MOSCA: Middleton on Sea Coastal Alliance
IP20045287

Melanie Jones & Mike Visram Co-Chairs
Comments for Deadline 4 including Hearing on May 15th and
Questions/comments/responses made

Agenda Item 6: b and c (Hearing 15th May 2024)

Figure 15.37h  
 Viewpoint 12: Bognor Regis sea front promenade

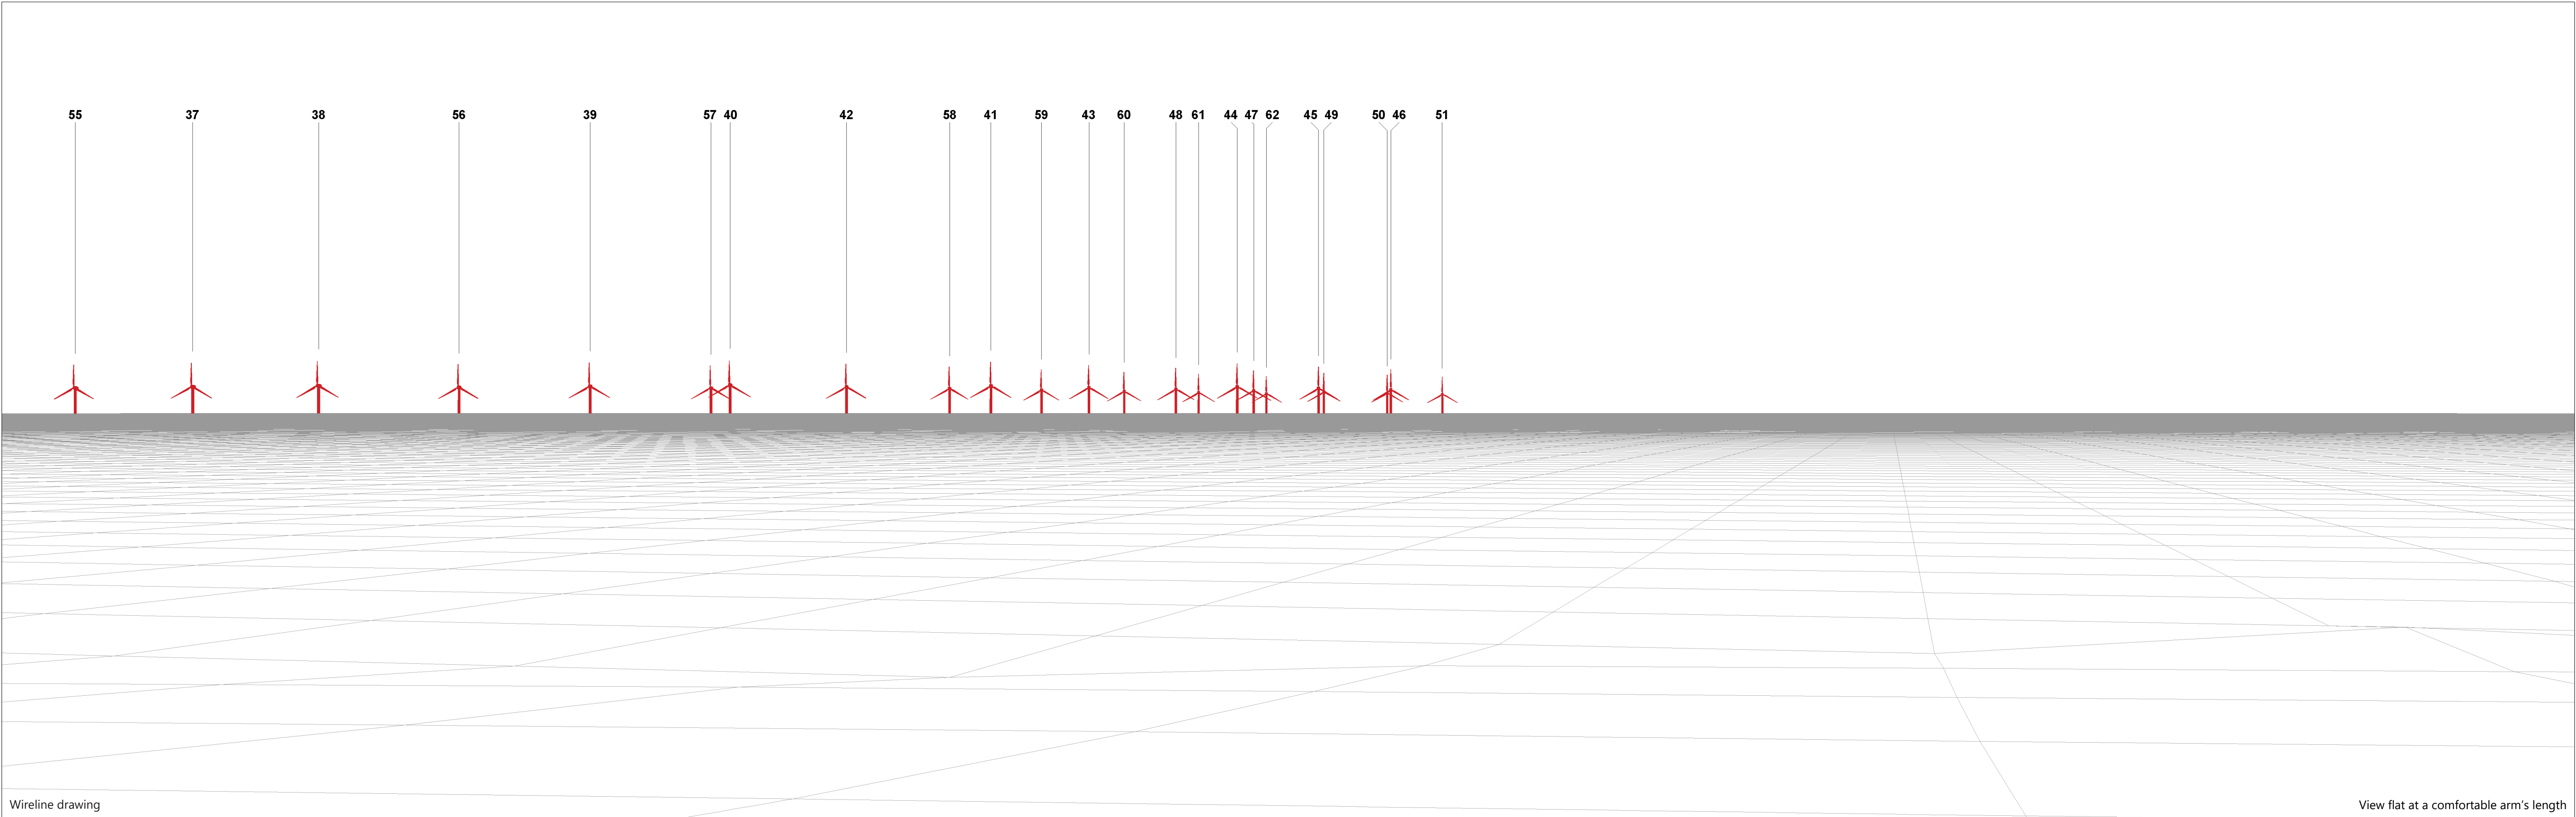
MOSCA has raised that with such a specific lack of visual representation of any sort for the view horizontally across the horizon– allowing for the Viewpoints from Clymping or Bognor. The lack of information makes it difficult to assess the likely impact to our coastline. (height, width number or emplacement). We have been denied any sort of pre-development visual. Rampion 1 is visible (significantly at times) to the left of the local Seascape. The Rampion 2 array will continue this without any break
